Engineers Comments Regarding Surface Water Drainage

Application Reference:	M/58/25/PL	Reviewer Reference:	ADC/KW/SB
Planning Officer:	Harry Chalk	Date of Review:	12/12/2025
Site Name:	86 Ancton Way Elmer PO22 6JP		
Application Description:	Demolition and erection of 1 No dwelling (resubmission following M/22/25/PL). This application is in CIL Zone 4 and is CIL Liable as a new dwelling.		
Assessment Number:	2 of 2

Reviewed Plans

- **Proposed Surface Water Drainage 006 PL3**
- **Flood Risk Assessment & Management of Surface Water Run-off- Revision B November 2025**
- **EA product 4 data**

PROPOSED SURFACE WATER DRAINAGE

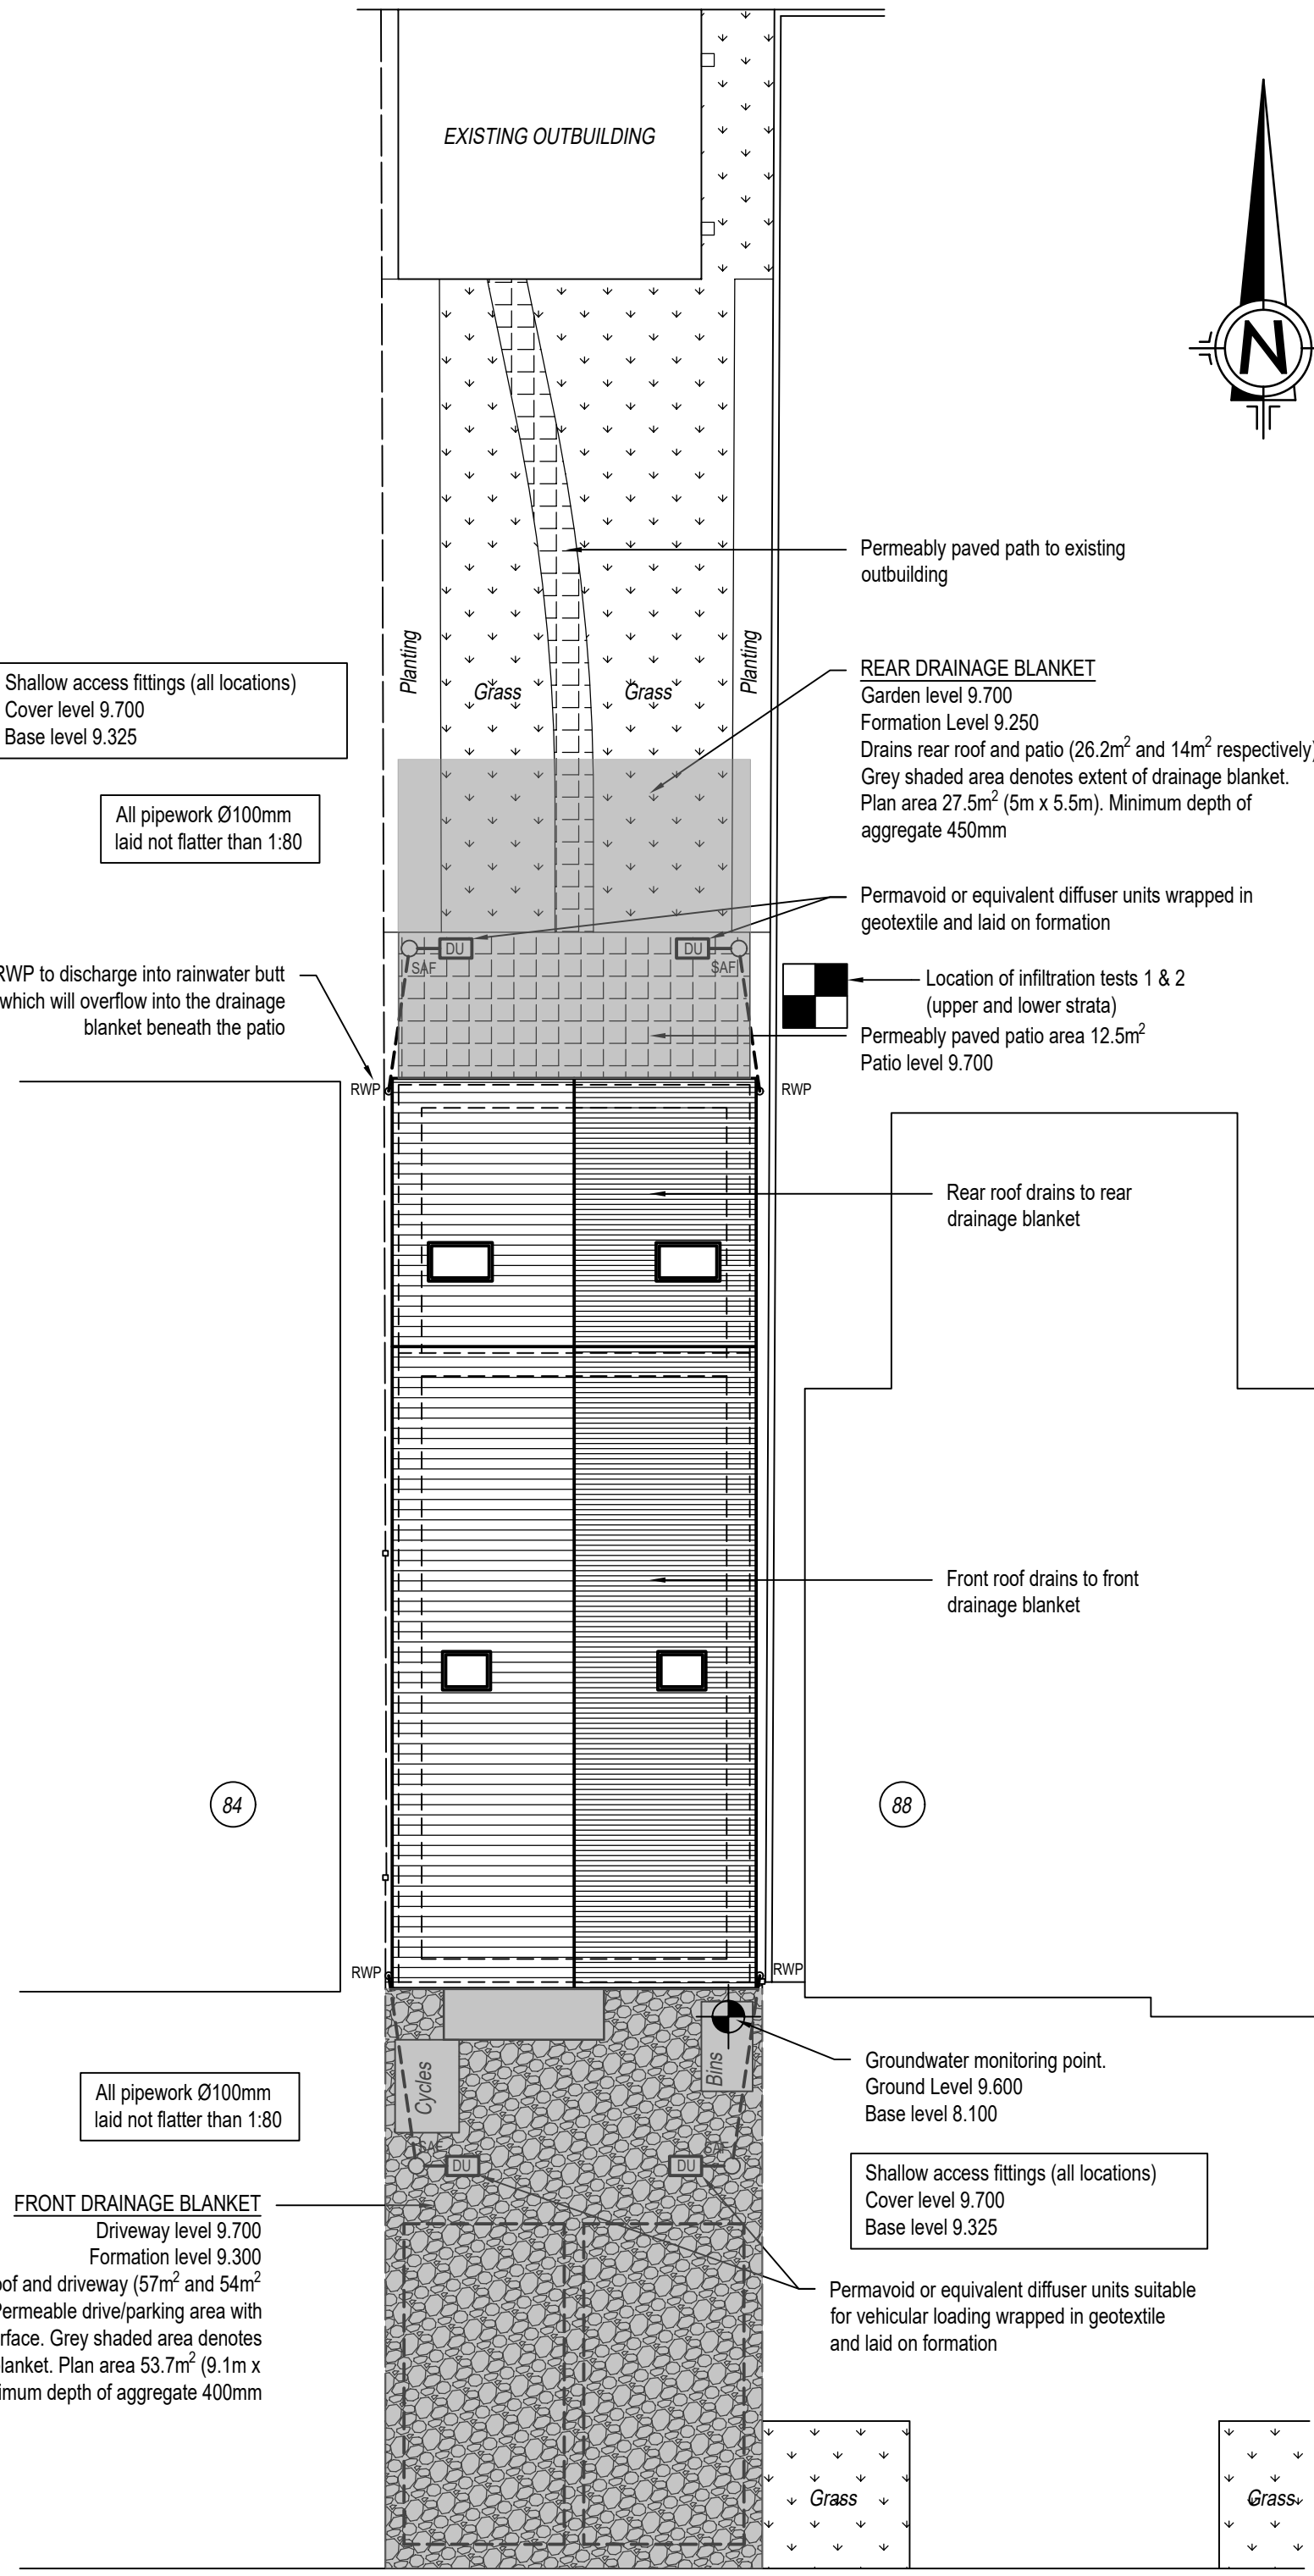
- 1.1. The designer proposes to drain the new dwelling and associated patio and driveway to 2 infiltration blankets at the front and rear of the house. We are supportive of the use of infiltration as the second highest priority disposal option (after water reuse). Despite further information being submitted the designer has still not adequately demonstrated that infiltration is viable. Nor have they presented any evidence of an alternative disposal location should that be the case. Therefore, it has not been demonstrated that the site can be sustainably drained, and an **objection** must be lodged.

- 1.2. Further to our previous review, an amended design has now positioned the infiltration blankets to both the front a rear garden no deeper than 9.440m, this is above the minimum allowable level of 9.370. This is broadly acceptable.

- 1.6. No alternative disposal location has been identified by the applicant, and infiltration, although likely, has not been proven viable. There remains a risk that a compliant disposal location for rainwater will not be achieved. Furthermore, it would not be reasonable to lift the objection and secure the disposal location via condition as further evidence may affect the size and scale of the proposed development.

3.2. Preliminary calculations have been submitted to demonstrate that the volumes of the proposed infiltration blankets are adequate for the site. It has now been clarified that urban creep has been applied and that a CV value of 1 has been used. However, we rely on the written confirmation of this within the FRA. This would require further detail and clarification for the final design, but are not a reason for objection at this stage.

SOIL INFILTRATION RATE TO USE (THE MINIMUM VALUE FROM THE THREE TESTS): 8.828E-06 m/sec

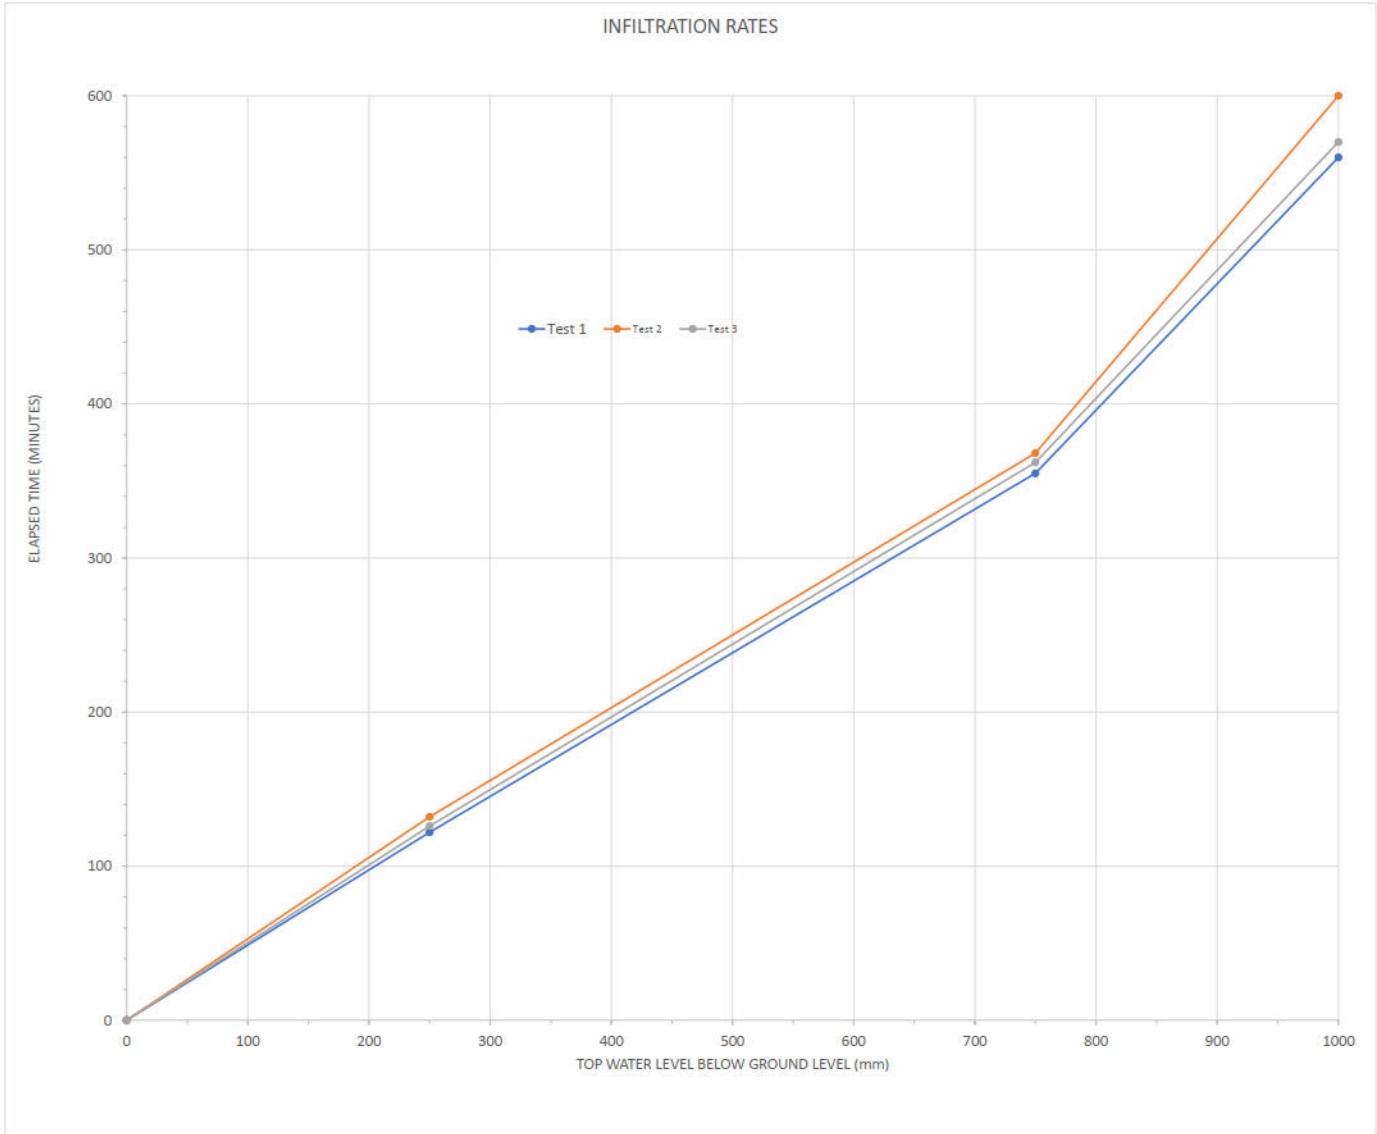
- 1.3. Details of the two sets of infiltration testing have now been provided. The applicant states that these tests are sufficient and have been undertaken in accordance with relevant guidance (BRE 365 and Part H of the Building Regulations). It has been explained that testing was carried out during works on a neighbouring property, where the trial pits (located on the boundary between properties) encountered chalk at 0.8 m depth. During those works, it was acknowledged that there was little variation in ground conditions across the site, resulting in foundations of the neighbouring building being positioned at approximately 1 m below ground level into the chalk layer. The agent asserts that there is no reason why this site would differ, nor any reason to discount the findings of Herbert Stumpp Ltd, who observed the testing at the time.

- 1.4. Objections to the quality of the infiltration testing remain valid. Clear evidence of the strata composition and confirmation that infiltration into made ground has not occurred have not been provided. Even if the descriptive findings of Herbert Stumpp Ltd are accepted at face value, testing was not undertaken at the correct depth to confirm that infiltration is viable.

- 1.5. One of the trial pits does not meet the size requirements set out in BRE 365, which stipulates trial pits should measure a minimum of 1m in length and 0.3m in width. The applicant claims that the overall calculation method is recognised by BRE 365 and Approved Document H of the Building Regulations (which allows smaller pits). However, BRE 365 specifically requires trial pits of the above dimensions, which then goes to form part of the calculation method. The methodology used in Approved Document H is not recognised or referred to by The SuDS Manual or the National Standards for SuDS and consequently is not accepted.
